**FURTHER COMMENTS REGARDING HERITAGE IMPACT
OF PROPOSED WORKS
AT WHALLEY OLD GRAMMAR SCHOOL, STATION ROAD, WHALLEY**

- 1.1 Further to my heritage statement of 21 December 2020, I make the following comments with regard to the revised proposals (dated 23 March 2021), which are to be resubmitted following the recent refusal of applications 3/2021/0006 & /0007. The statement of significance provided previously within that earlier document remains valid.

South Elevation

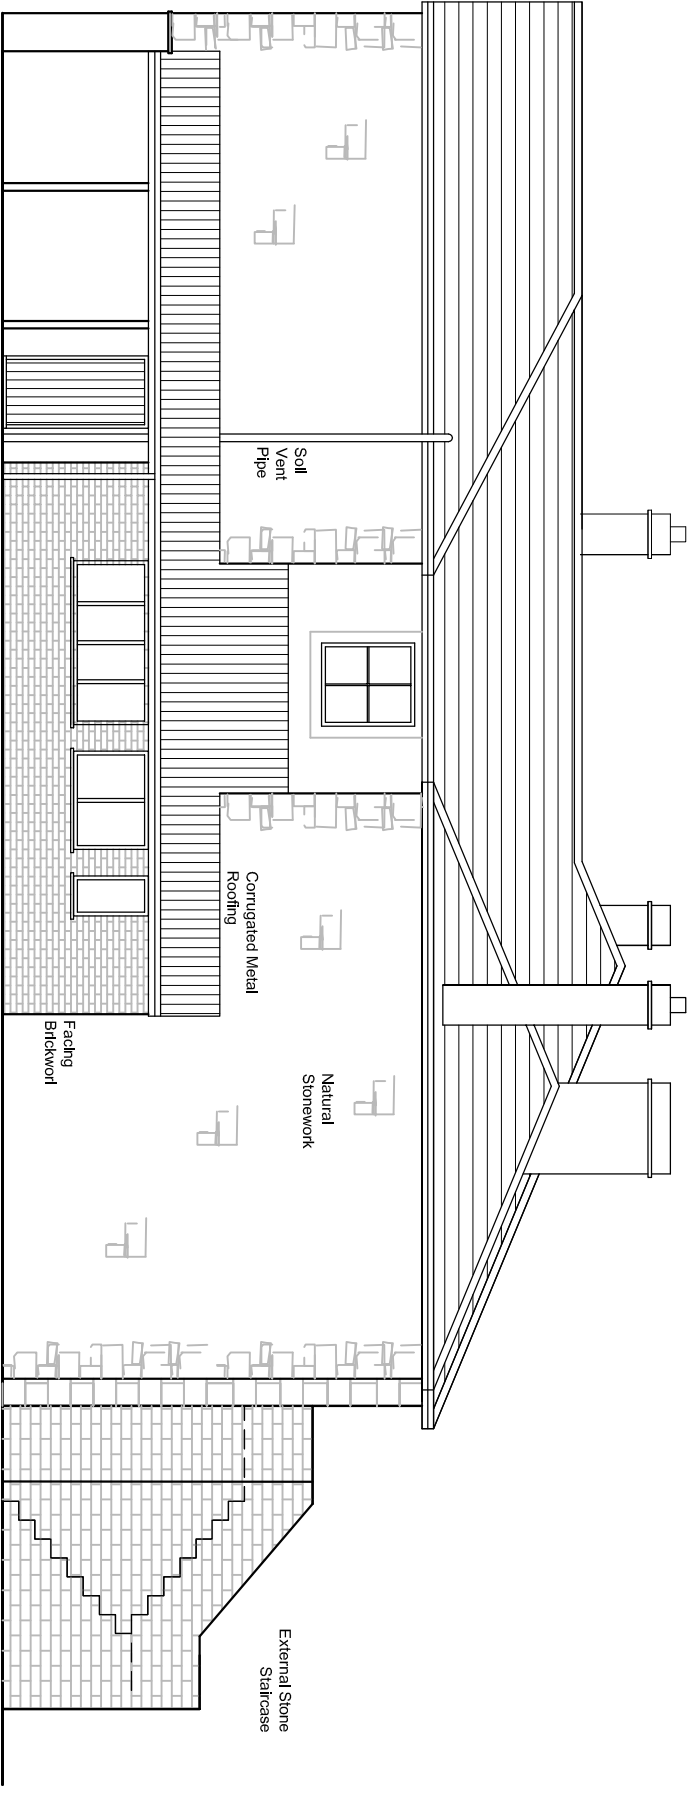
- 2.1 The amendments to the changes proposed for the south elevation are an improvement, which I believe is acceptable in terms of heritage impact. The reinstatement of the south entrance would have a neutral impact on the appearance of the building, and the glazed screen proposed for the enclosure of the smaller outdoor play area would be preferable over steel railings, as they would be an obvious addition to the historic building, without the industrial connotations which steel carries. It is considered that no harm would arise from these aspects.

West Elevation

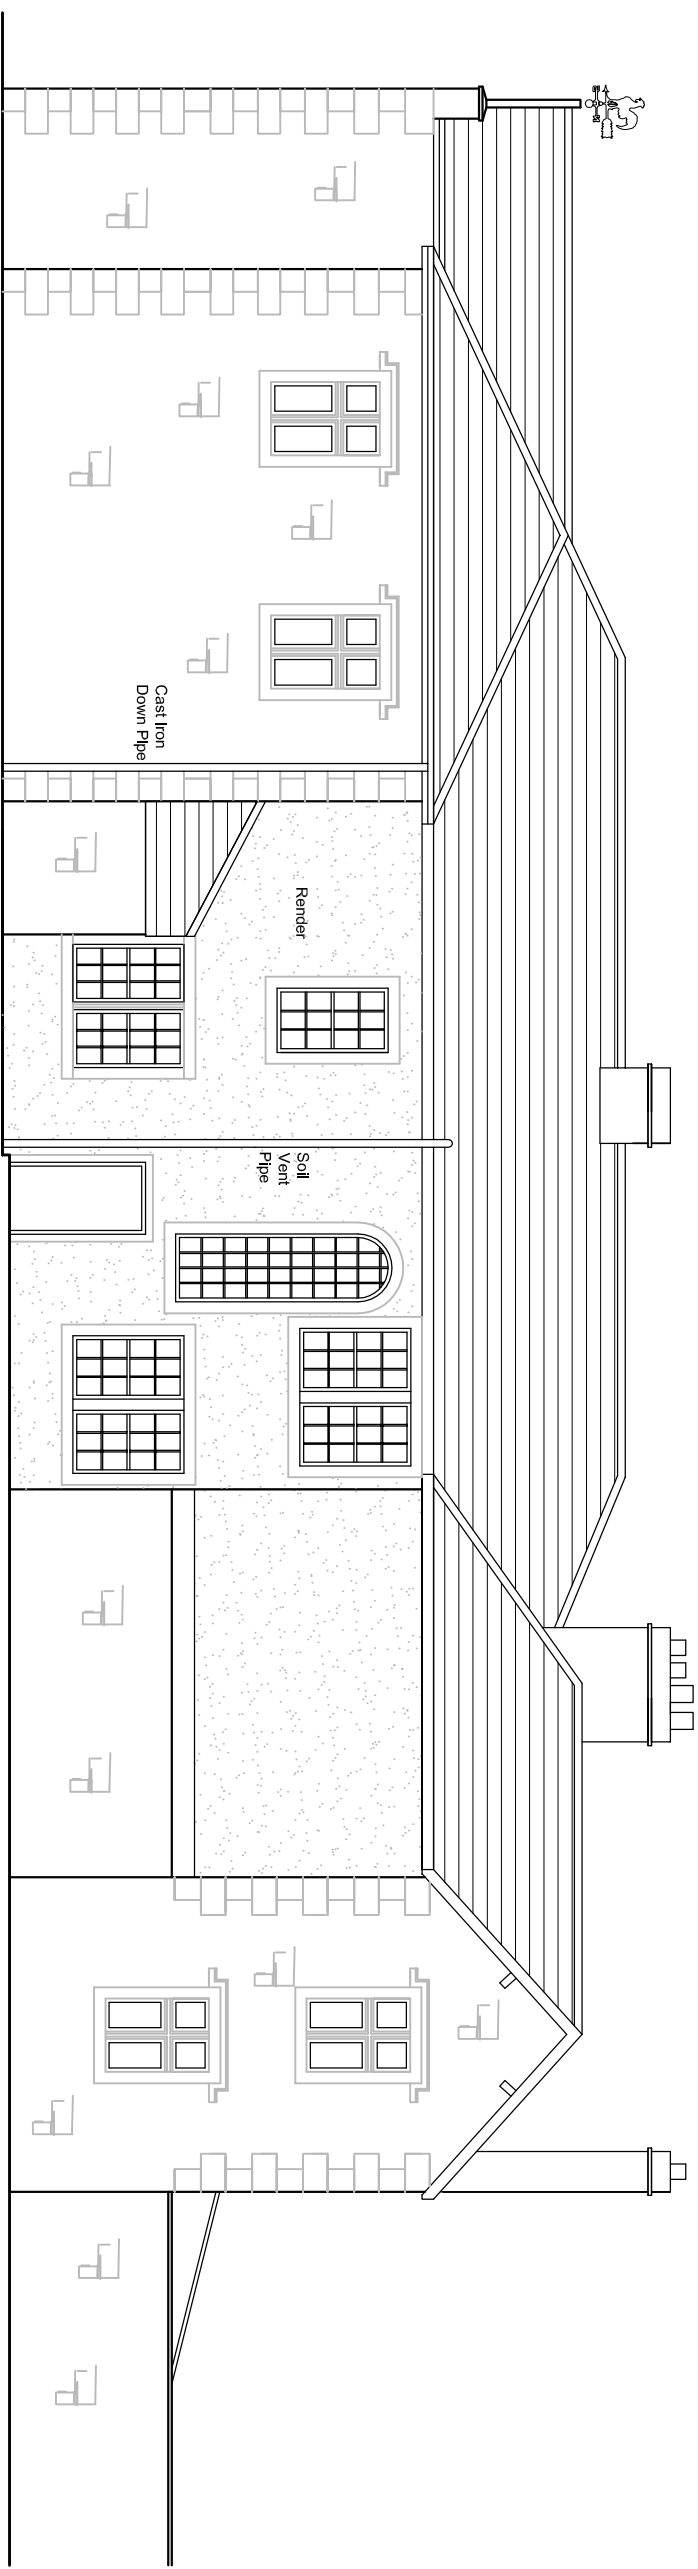
- 2.2 The amendments to the proposed replacement single-storey extension to the west elevation mean that this element of the proposal closely replicates the dimensions of the existing structure, and represents an improvement (enhancement of the heritage asset), by virtue of the stone and slate finish, without excess glazing to walls or roof.
